Application for removal or variation of a condition following grant of
planning permission. Town and Country Planning Act 1990.
Planning (Listed Buildings and Conservation Areas) Act 1990

Number	114
Suffix	
Property name	
Address line 1	Copse Wood Way
Address line 2	
Address line 3	
Town/city	Northwood
Postcode	HA6 2UB

Single storey rear extension, conversion of garage to habitable use and conversion of roofspace to habitable use to include 2 rear dormers, 2 front rooflights and a side rooflight with alterations to fenestration.

15807/APP/2020/2995

rev:	date:	description:	
scale:	1 : 250	A2	date: 17 / 09 / 2020
drawing no:	1356 / P / 1 ^B		drawn: TF
drawing:	HOUSEHOLDER APPLICATION PROPOSED SITE LAYOUT & LOCATION PLAN		
project:	114 COPSE WOOD WAY, NORTHWOOD, HA6 2UB		
client:	MR AND MRS POPAT

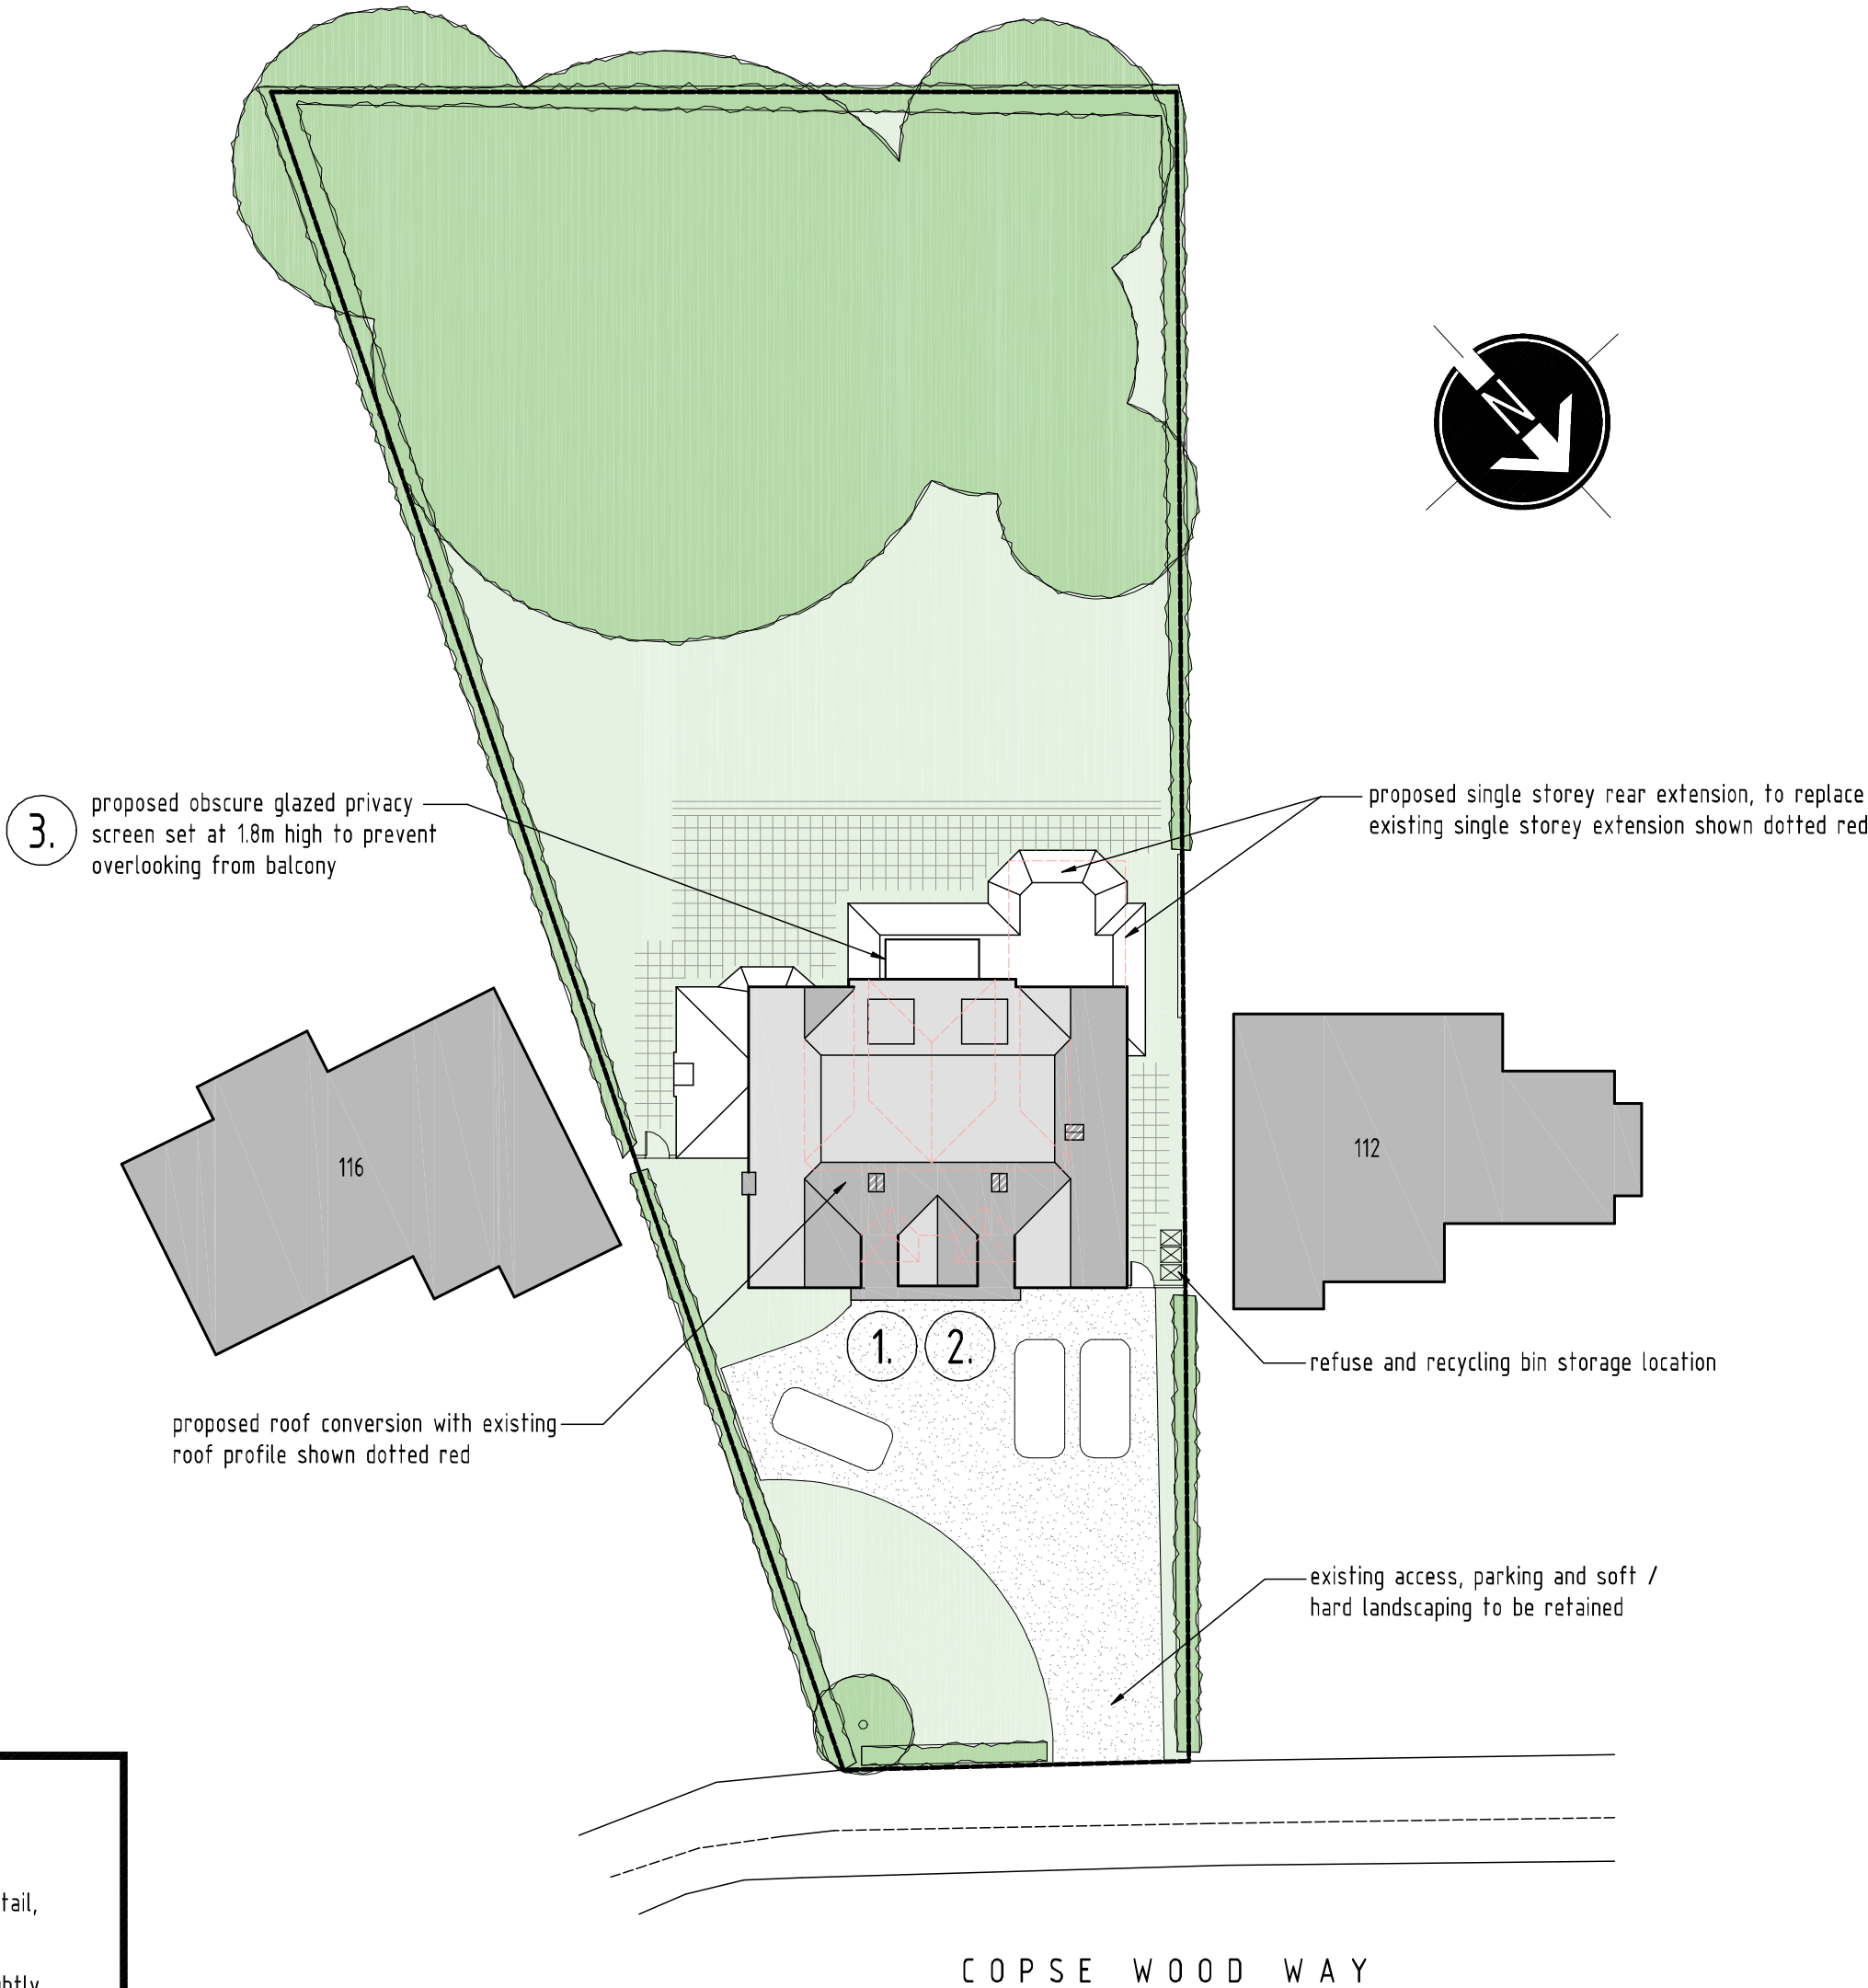
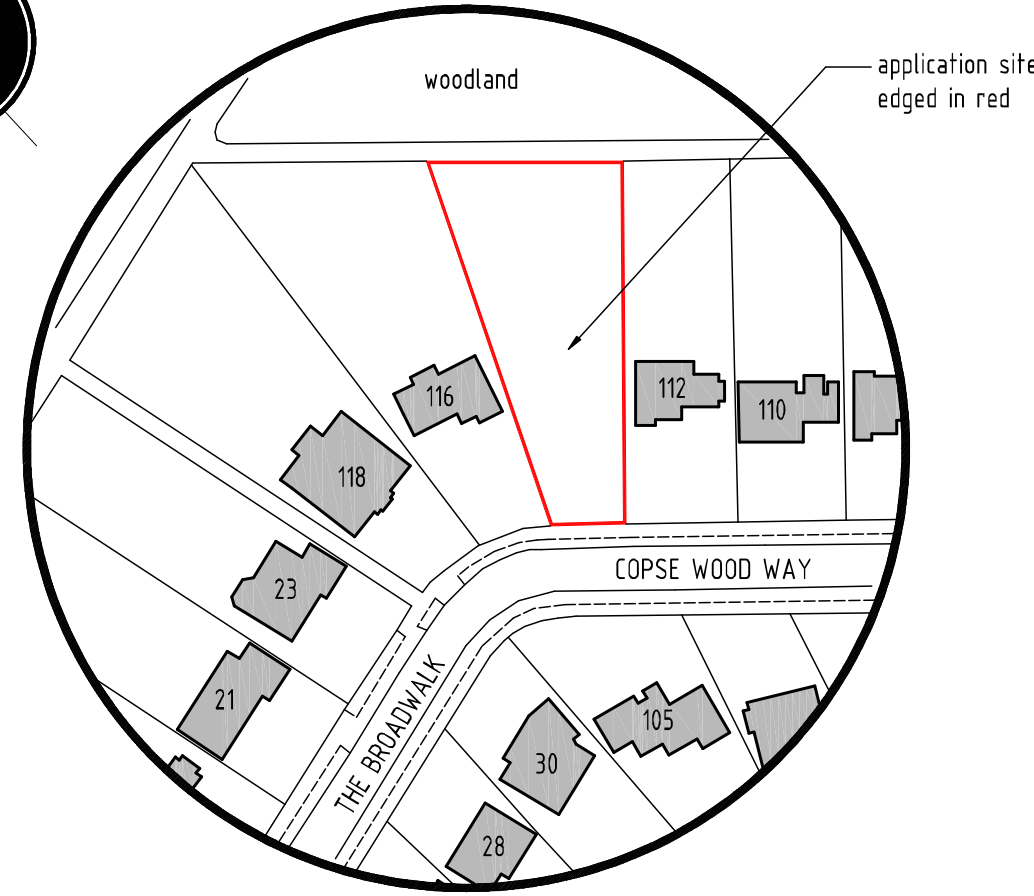
To allow for the changes to the porch / roof, front dormer and rear balcony.

Replace the approved drawings 1356/P/1A and 3A with the new drawings 1356/P/1B and 3B.
